**From:** City of Kittitas Building Inspector <building@cityofkittitas.com>  
**Sent:** Monday, January 06, 2014 11:58 AM  
**To:** Jeff Watson  
**Subject:** Re: BL-13-00031 Clerf

A surveyed map showing the current configuration of the property and the proposed configuration of the property. It is of the utmost importance that we can see which boundary line is being adjusted.

**BOUNDARY LINE ADJUSTMENT SURVEY**

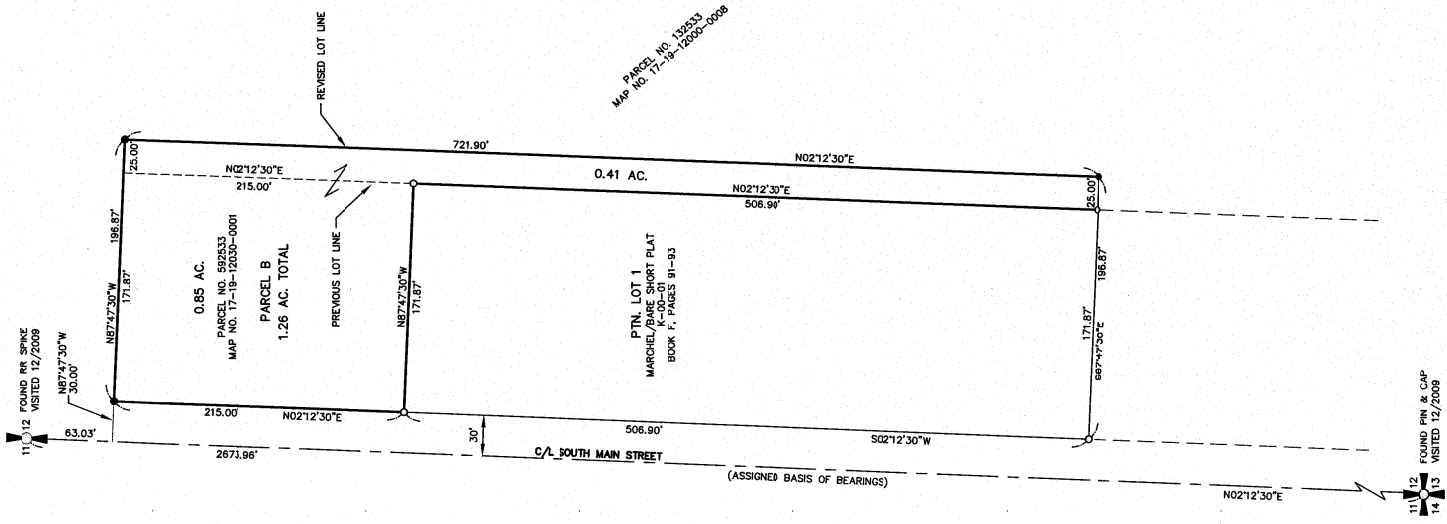
A Title Report is very useful, but so is the Surveyor's stamp assuring that the required information provided is accurate. There is a deed provided, but not a Title Report.

Debbie has forwarded the Clerf BLA to me for review and comment, which I have been working with our planner on. Our planner is requesting some additional information in regards to the Clerf BLA before she is willing to comment. The county map does not seem to match that of the recorded survey that has been submitted. I am assuming that you have access to an updated map on these properties? Please let me know if there is any additional information that we can provide to her to make this more clear. Please feel free to contact me with any questions you may have in regards to this request.

Surveys may be recorded that do not reflect the actual parcel configuration as recognized by the county... I know, weird huh!... so essentially the applicant recorded his proposed configuration assuming it would be approved. Think of it as me recording a document that says the moon is made of cheese; it doesn't make it so, only that I'm dumb enough to officially claim it to be so. Obviously this can be a bit more confusing when it comes to surveys and land use. I don't know why they allow it, but they do. This is why title reports are sooooo essential. For review purposes on this application think of that recorded survey as a "Proposed Configuration" map.
